FALCON HIGHLANDS SOUTH FILING 1

LOCATED IN SECTION 12, TOWNSHIP 13 SOUTH, RANGE 65 WEST OF THE SIXTH PRINCIPAL MERIDIAN, COUNTY OF EL PASO, STATE OF COLORADO CONSTRUCTION PLANS

EPC STORMWATER REVIEW COMMENTS IN ORANGE BOXES WITH BLACK TEXT

CHALLENGER HOMES
FALCON HIGHLANDS SOUTH - FILING 1
EL PASO COUNTY, COLORADO
CONSTRUCTION PLANS
COVER SHEET

CHALLENGER HOMES
 FALCON HIGHLANDS SOUTH - FILING 1
 EL PASO COUNTY, COLORADO
 CONSTRUCTION PLANS
 EROSION & SEDIMENT CONTROL PLANS
 INITIAL 1

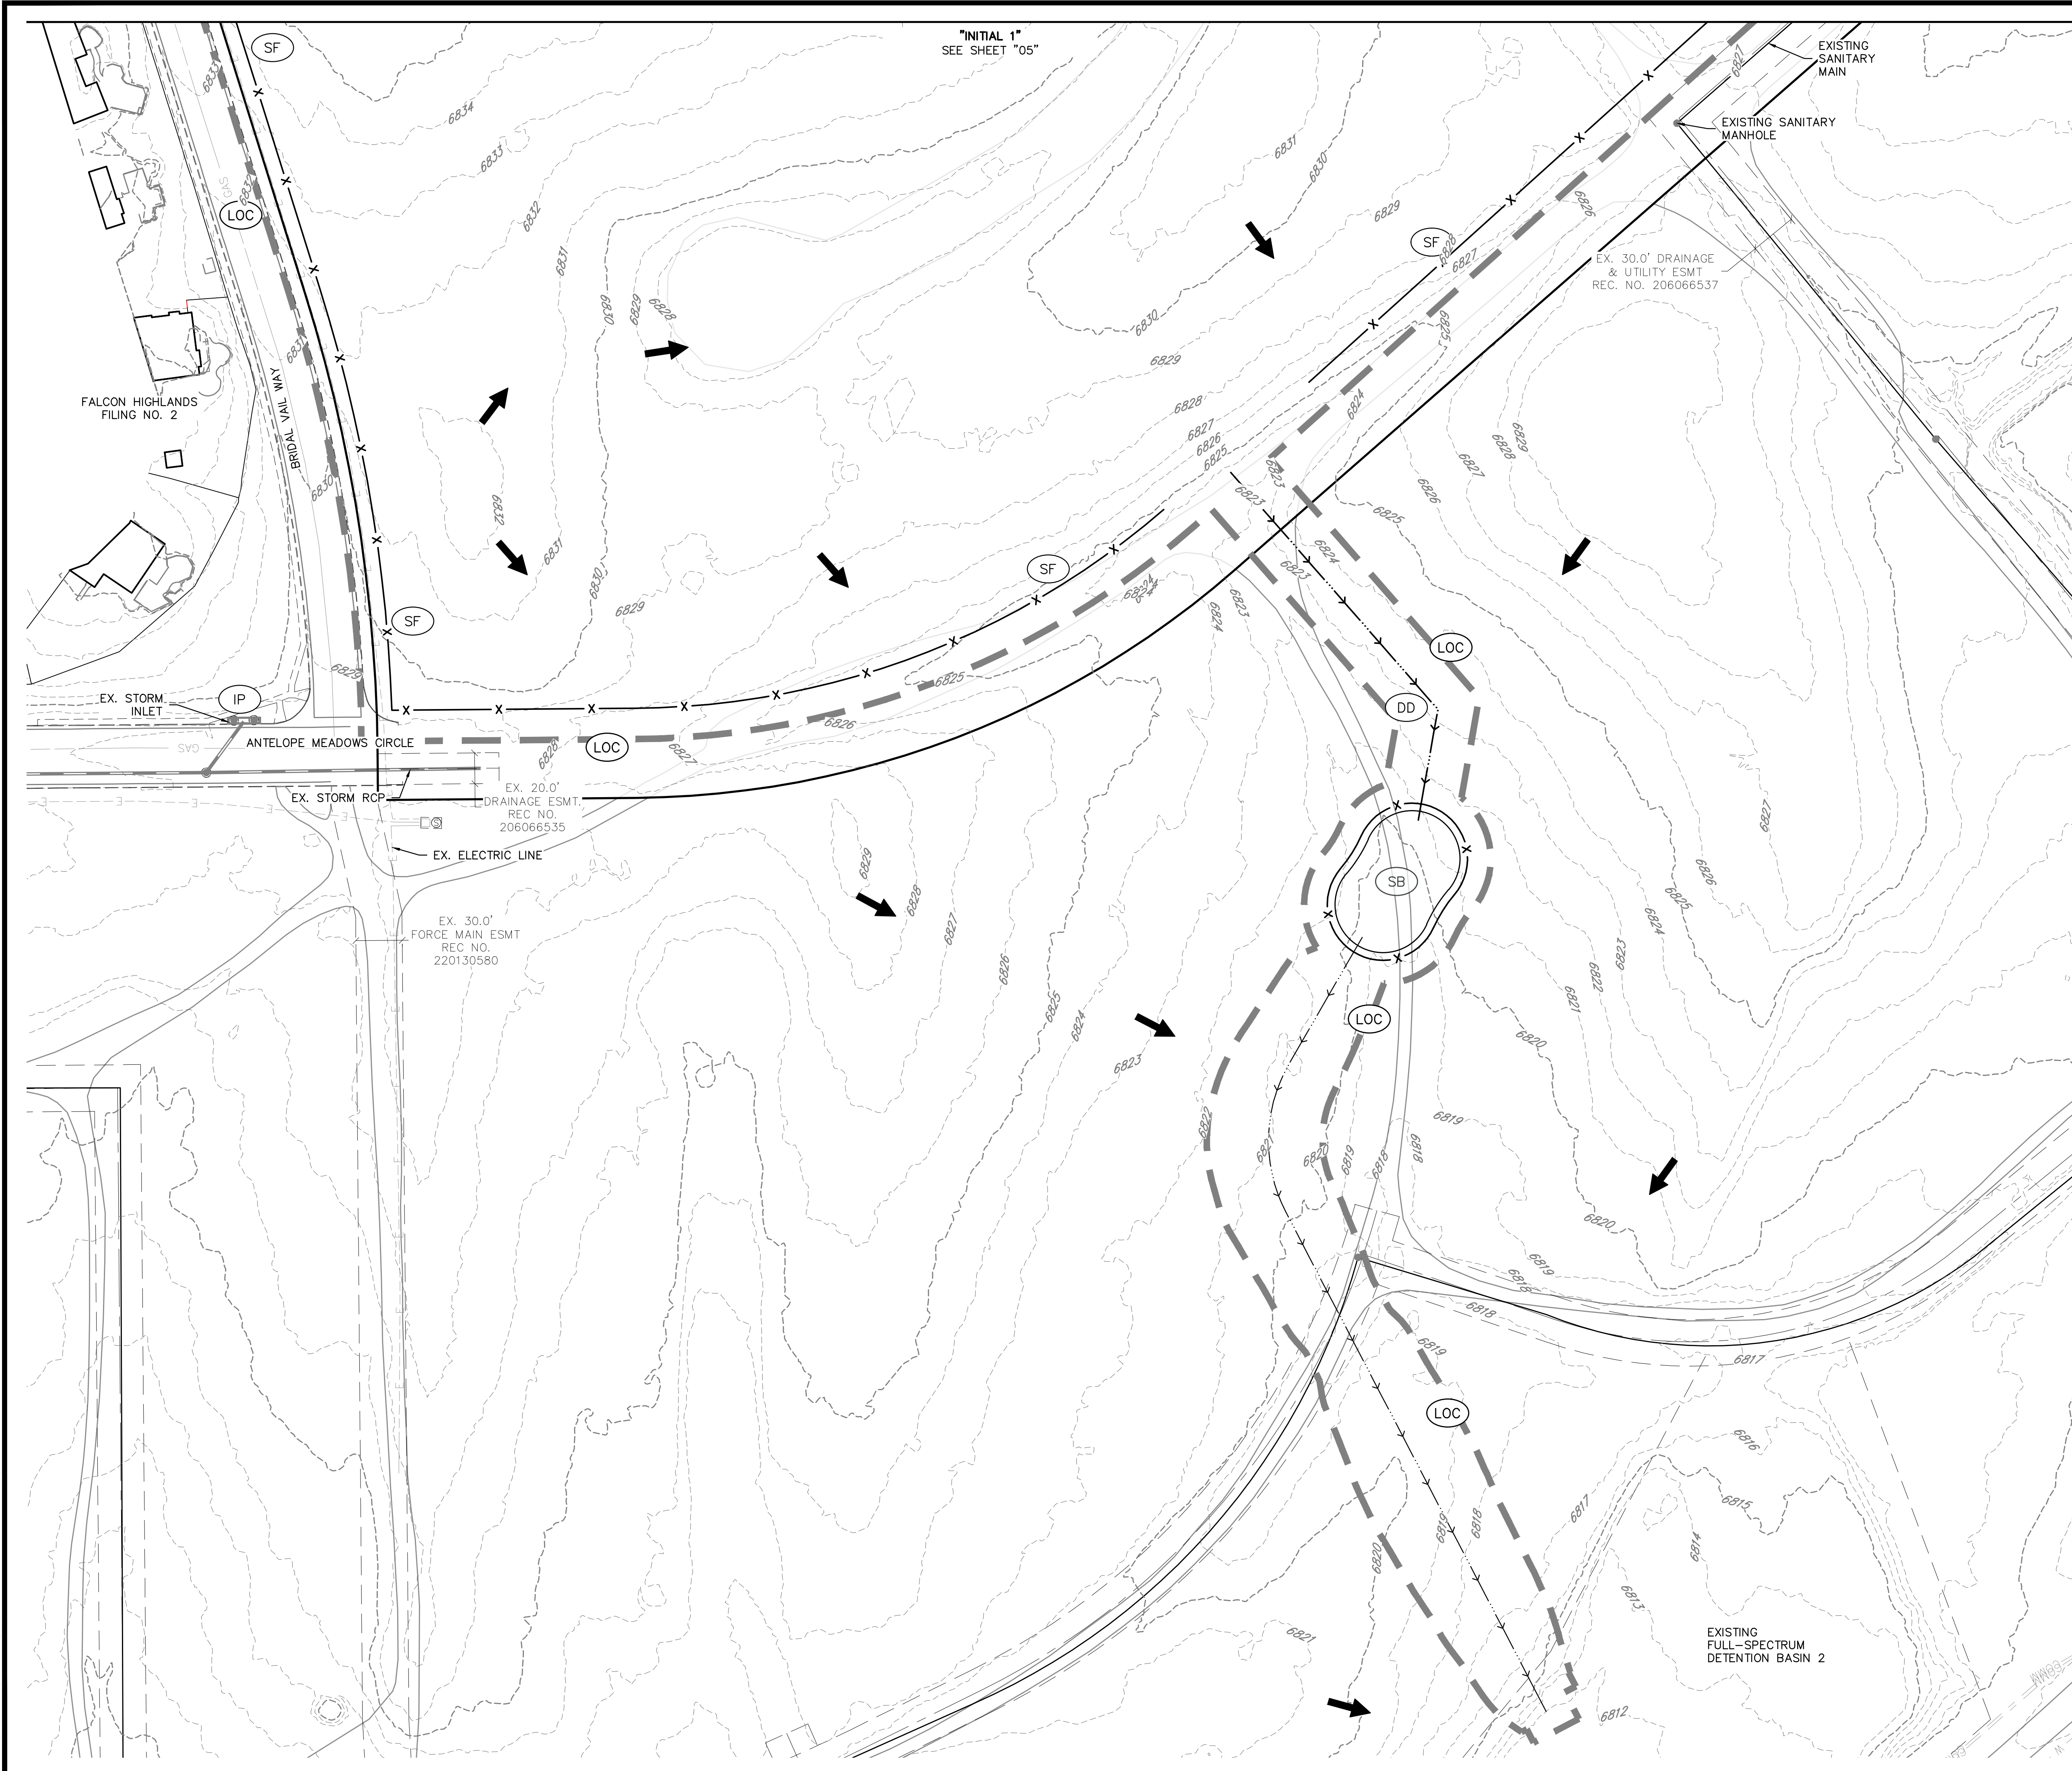
GEC Checklist Items H and M. If "limits of disturbance" and "construction boundary" are the same, change to "limits of construction/disturbance" or otherwise show as separate line types for each on the legend and figure. Limits of Disturbance is not currently shown.

updated to include "disturbance"
